Application No: BN/57/26/HH
Site Address: 43 Elm Grove Barnham PO22 0HL
Description of works: Erection of single-storey extension to front elevation of existing dwelling.

Thank you for your internet representation made on 25th May 2026 which has been recorded as an objection with the comments as follows:

FOR MR S. DOWNES		
SITE 43 ELM GROVE, BARNHAM, WEST SUSSEX. PO22 0HL		
TITLE PROPOSED EXTENSION BLOCK PLAN		
SCALE 1: 500 © A3	DRAWN AH 03/26	DRAWING NO. 01B REV.

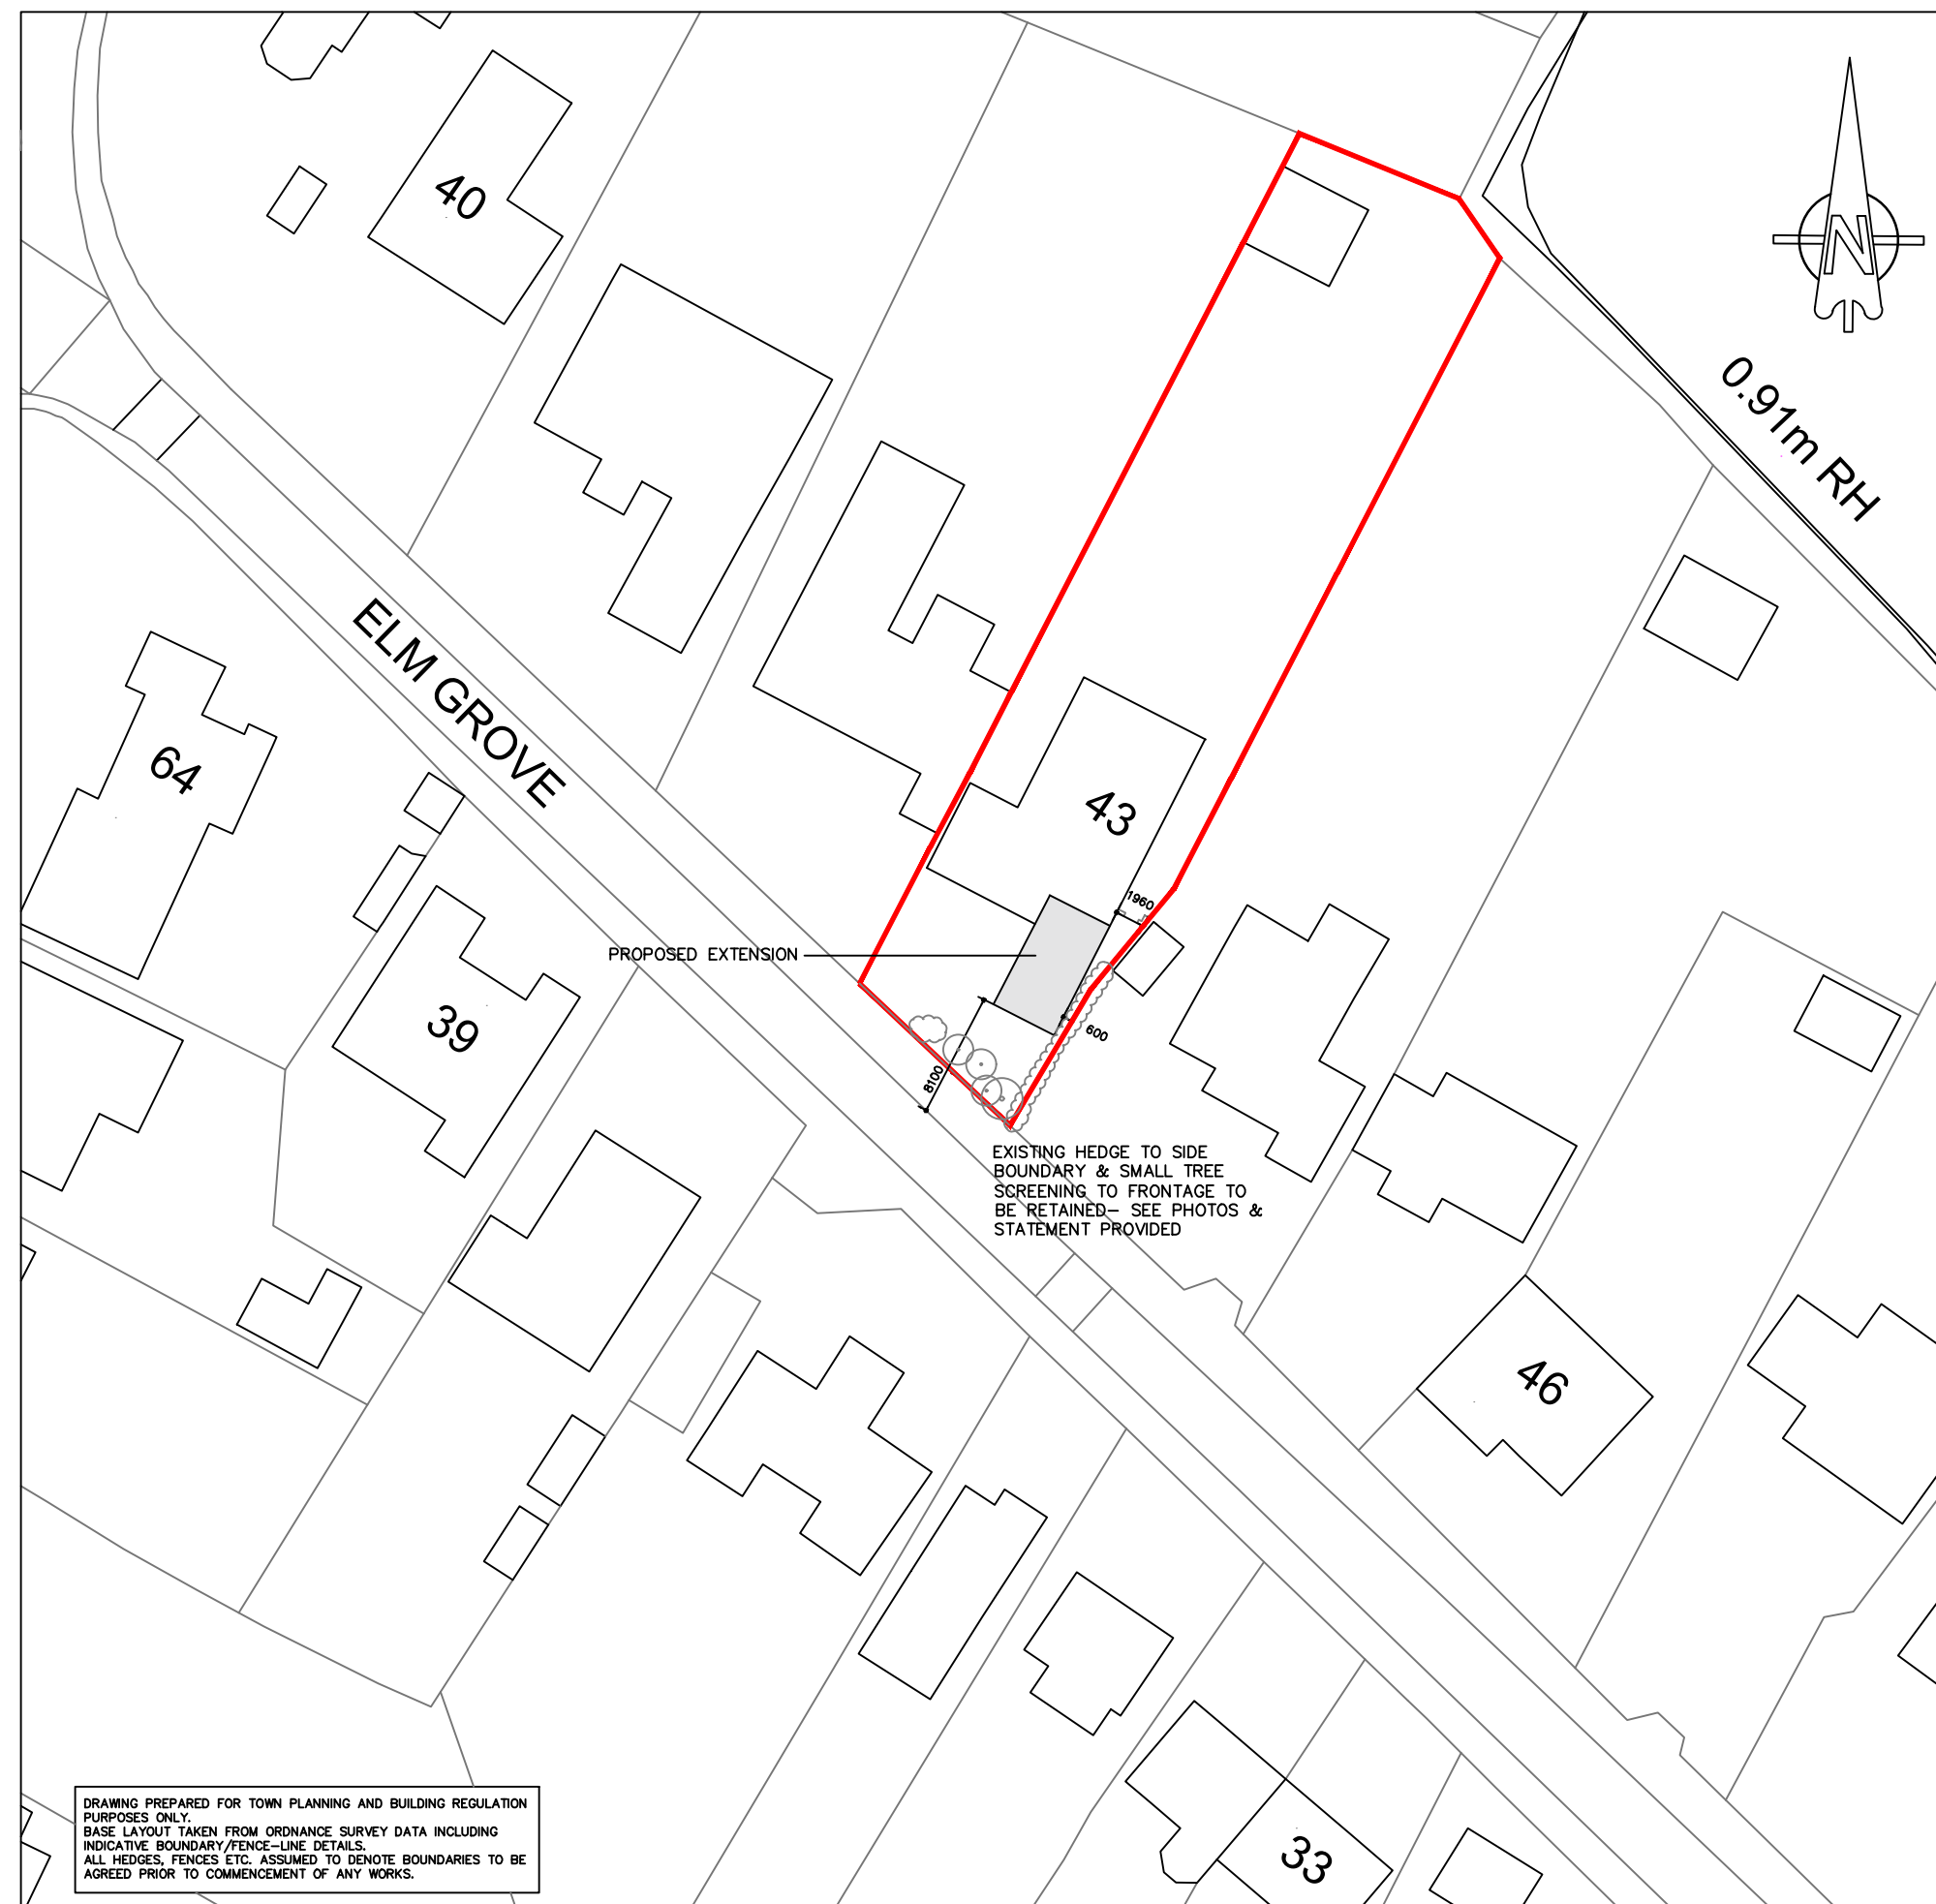
As previous objection to application BN/122/24/HH, object to application BN/57/26/HH on grounds of surface water flooding. Although the new application is single storey, the surface area is exactly the same, and the same limitations on permeable surface areas within the grounds remain due to the covering over of 70% of the garden area with impermeable porcelain tiles, the building of a 10 metre swimming pool, and a large garden cabin of some 25 square metres. The result has been excessive run-off of surface water into adjoining gardens.

Secondly, the overall front to back length of the dwelling would be excessive. In the statement from the applicant, Paragraph 8 compares the front to back length of adjoining properties, using measurements taken from Google Earth as justification for this extension. In fact, Number 44 Elm Grove is maximum (including porch on front) 17.1 metres front to back, some 22% less than the fictional figure presented in the statement. If the india-rubber measure used to estimate the front to back length of No 44, was also used for numbers 42, 41 and 40, their actual figures will be some 22% less as well, resulting in measurements as follows: No 42 approximately 19 metres, No 41 approximately 19 metres, No 40 approximately 17 metres. The existing house at Number 43 is already some 16.75 metres including the wrap-around front porch. The proposed extension pushes this figure up to 23 metres.

Thirdly, and notwithstanding the extension at No 41 which stands forward of the main building, generally the houses on Elm Grove are set back from the road by between 10 and 15 metres (with one exception at No 46, built in 1906). This "building line" is enforced by covenants restricting building within 30 feet of the front boundary.
